From: Michael Eastham
Sent: 27 November 2020 13:01
To: Planning Scanning
Subject: FW: P1456i Manor Nursery - Conditions 6, 21 and 22 - Reference A/166/20/DOC

Condition 21- surface water drainage design

From: Laura Gibbons <laura.gibbons@arun.gov.uk> [REDACTED]
Sent: 18 August 2020 07:25
To: Michael Eastham <Michael.Eastham@arun.gov.uk>
Cc: Paul Cann <Paul.Cann@arun.gov.uk>
Subject: Fwd: FW: 22995 - Manor Nursery A/86/20/DOC - Designer Response

CLIENT Roffey Homes Ltd	
PROJECT Manor Nurseries Site Angmering	
TITLE Proposed Maintenance Ownership Plan	
DRAWN P Reynolds	DATE Dec 2020
ENGINEER S Burgess	CHECKED
SCALE 1:250 @ A1	PROJECT NO. 22995 Dwg. No. REV. 120

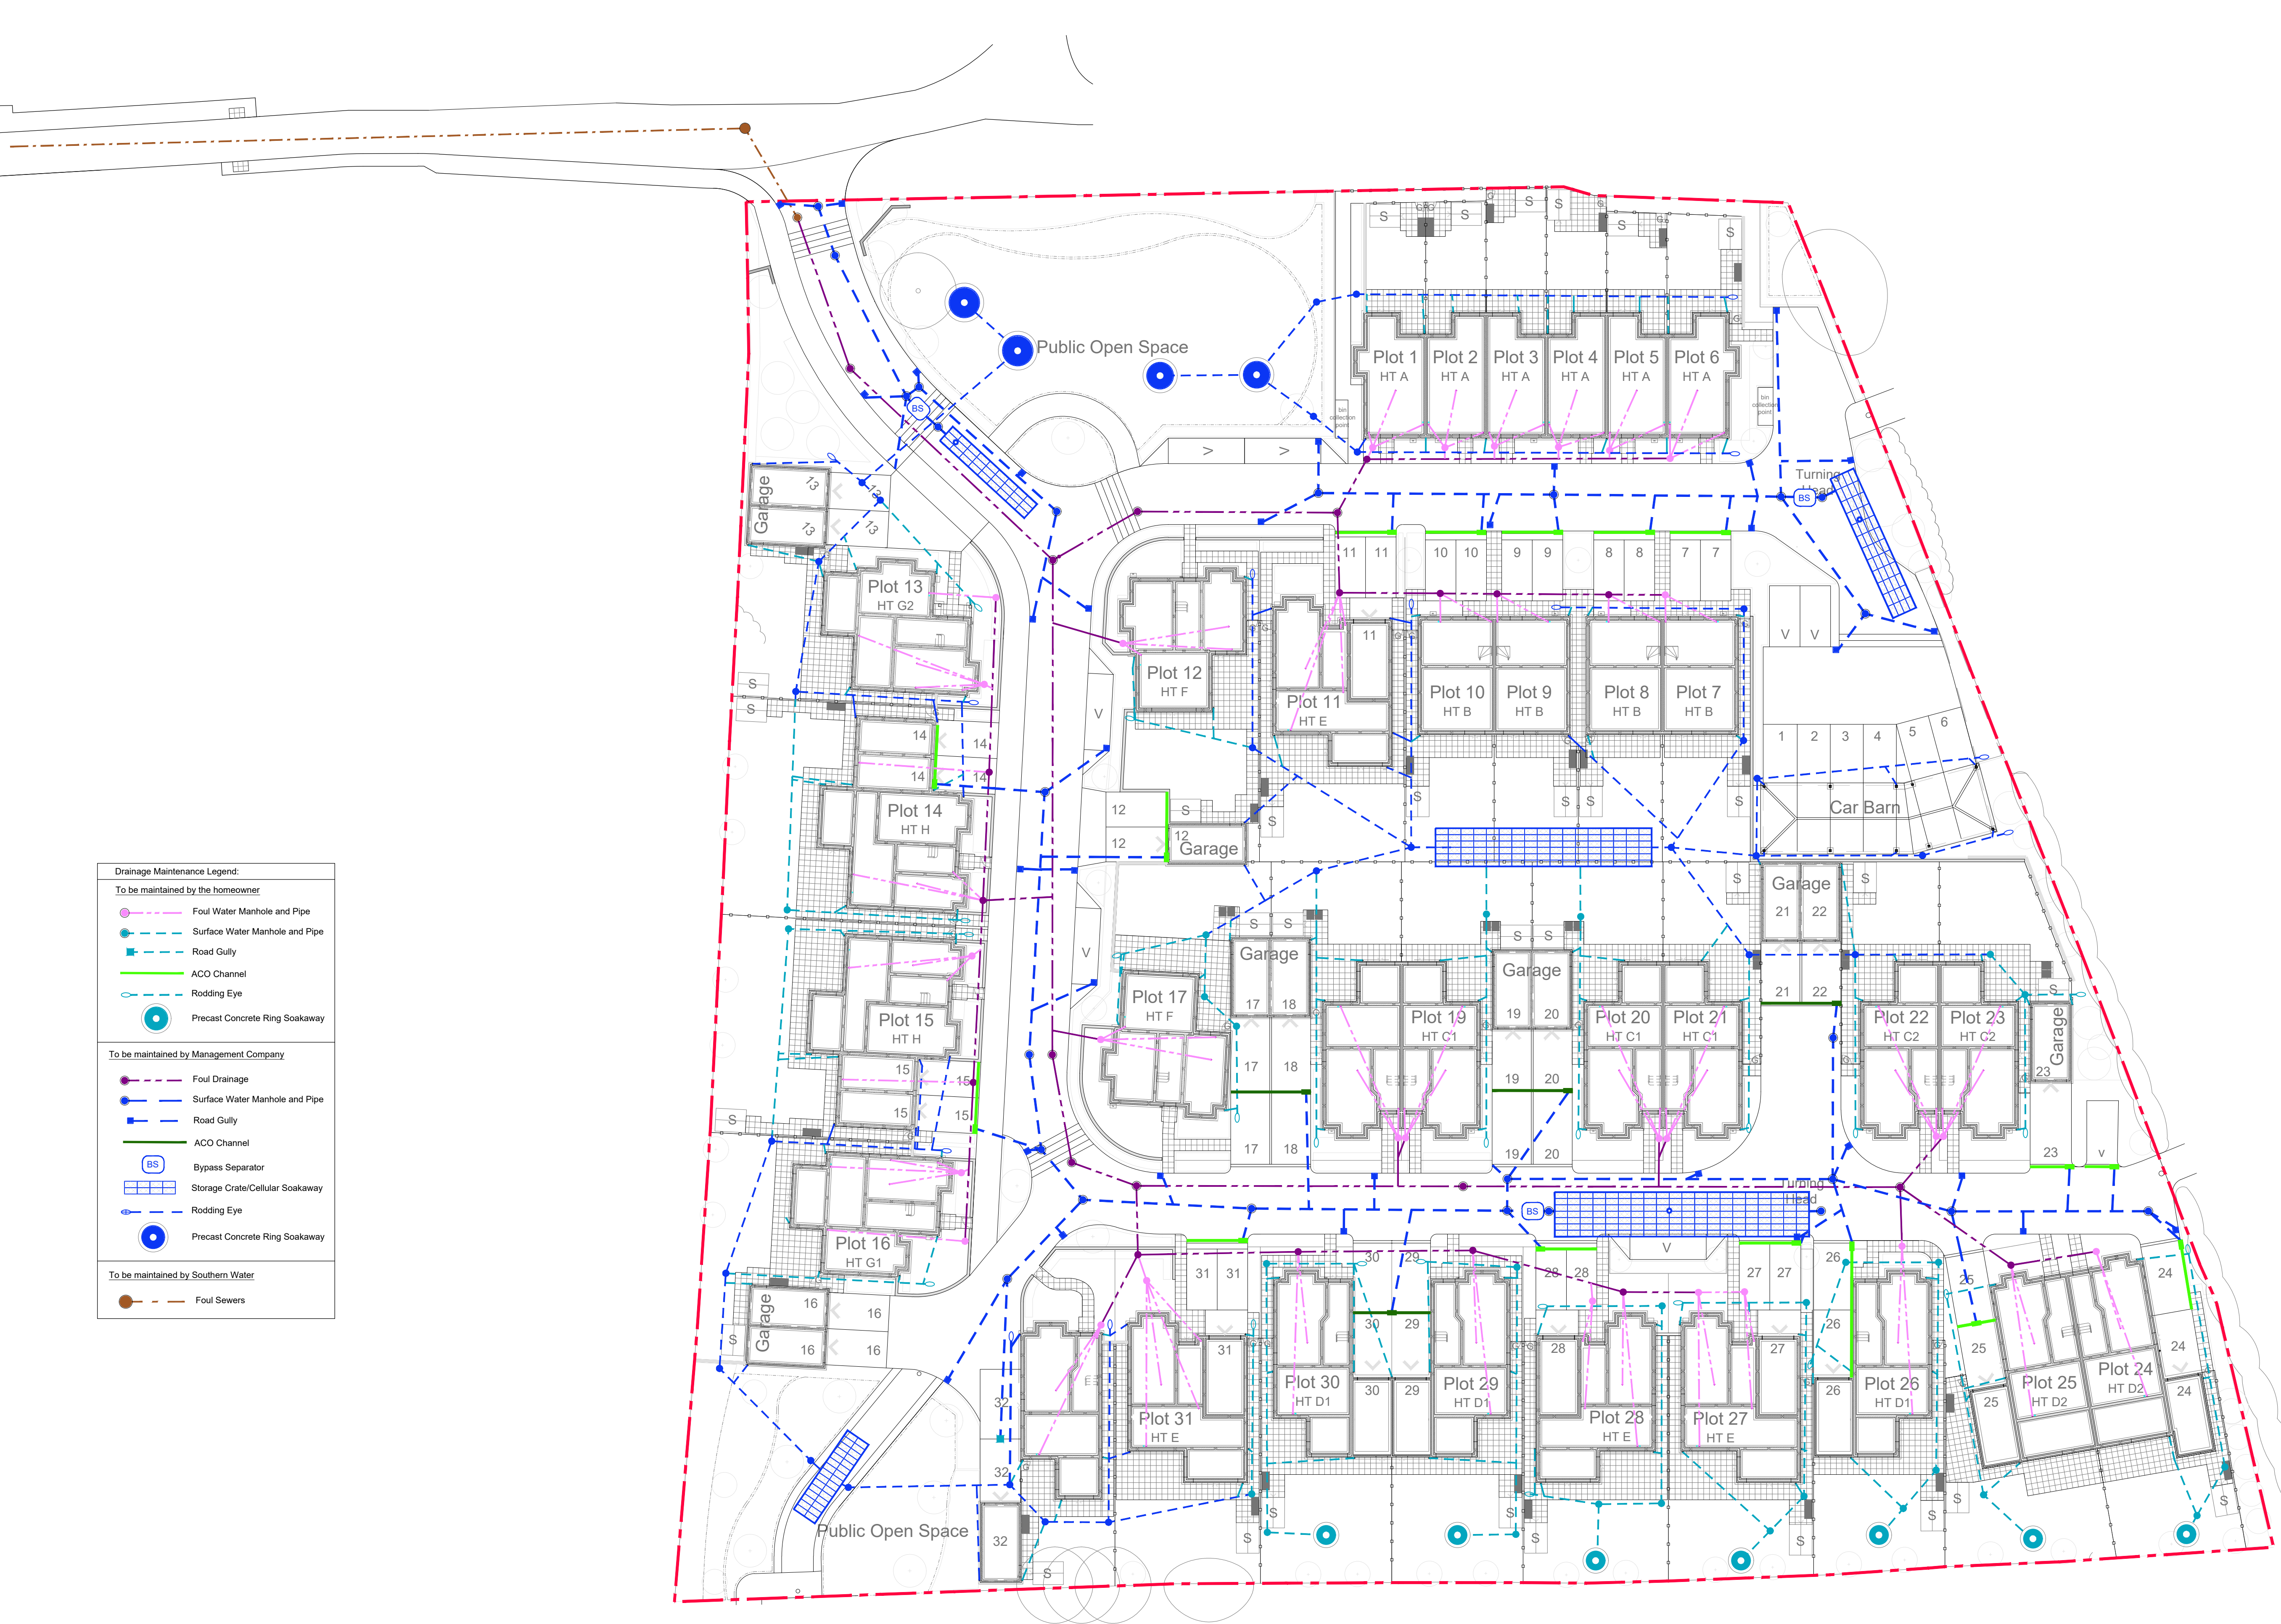
It is not appropriate to review this condition until the drainage design is agreed.

Given the response to the Conditions above we request the SuDS Maintenance Plan be reviewed and approved. *This will be reviewed once the surface water drainage strategy and design for the site has been agreed.*

TYPICAL SOAKAWAY DETAIL
(LESS THAN 3m DEEP)
(Scale 1:20)

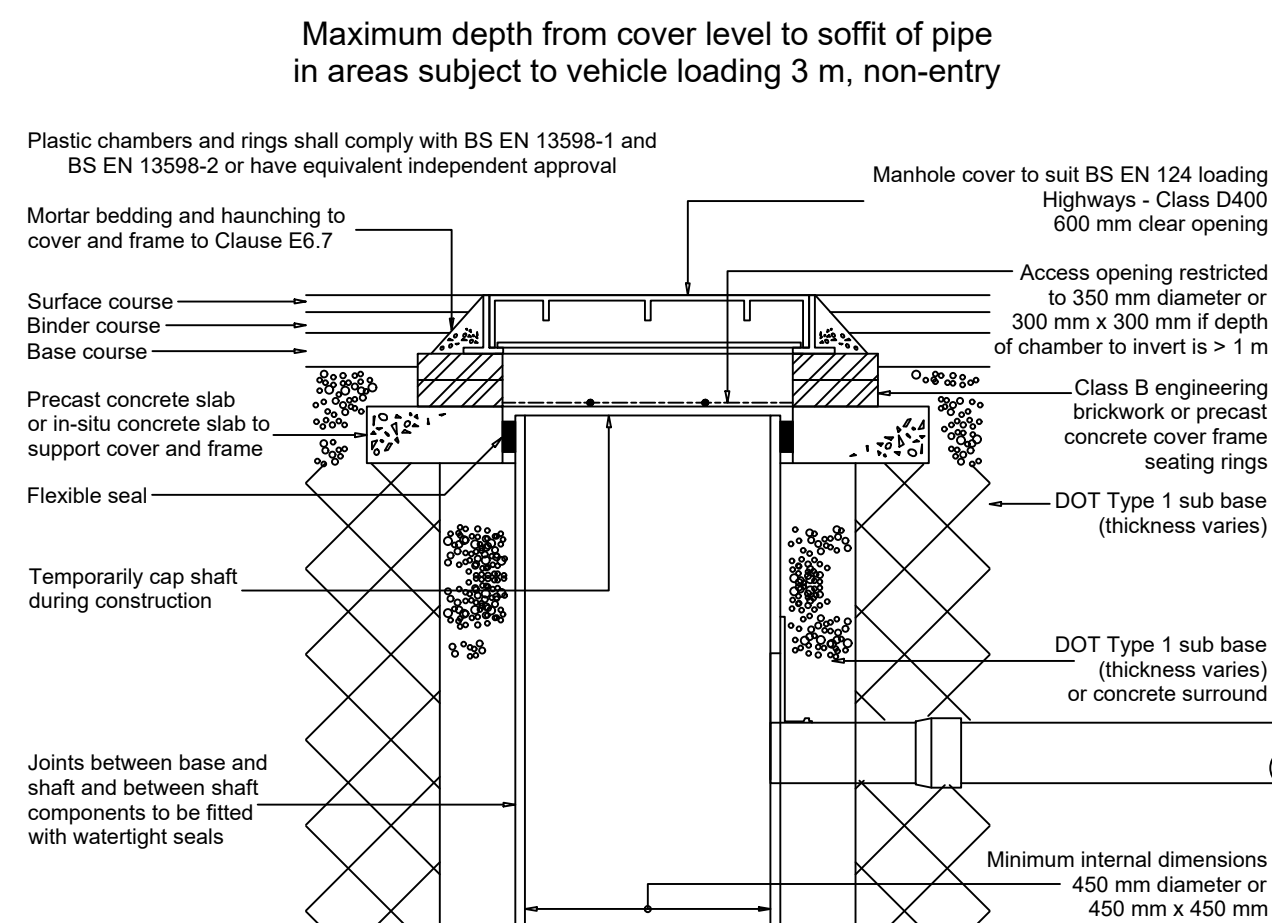
3. All infiltration tests were undertaken at circa 2.5m depth, yet some of the soakaways are considerably shallower than this.

We will require further information on how adequate treatment of surface water is occurring prior to discharge to ground in accordance with chapter 26 of CIRIA C753. There is no evidence of any pollution mitigation prior to discharge to soakaways. This is a particular concern regarding water from highways where pollution hazard indices are higher.

The design notes only two soakaway designs with the base shallower than 2.5m bgl. These are SA8 and SA9 and both are located within the gardens of the properties along the southern boundary of the site. Soakage testing was undertaken at a depth of 2.5m within the gravel strata below the site. The trial pit logs within this area, TP1, TP2 and TP3, confirm the gravel strata is located at between 2.1 and 2.2m below ground and extends to the base of the trial pits. SA8 and SA9 soakaways are situated within this gravel strata. We therefore request this objection is removed based on the designed soakaways' depth extending into the tested soil strata where they will have the same performance as the tests. We have attached the Trial Pit data and location plan. *Acknowledged that the same strata does just about extend to base, however ring soakaways are proposed which rely upon sides for infiltration only therefore they will not be utilising this gravel strata. We would recommend that these soakaways are made deeper to extend further into the gravel strata, but the base must be kept above peak groundwater levels/ base of monitoring wells.*
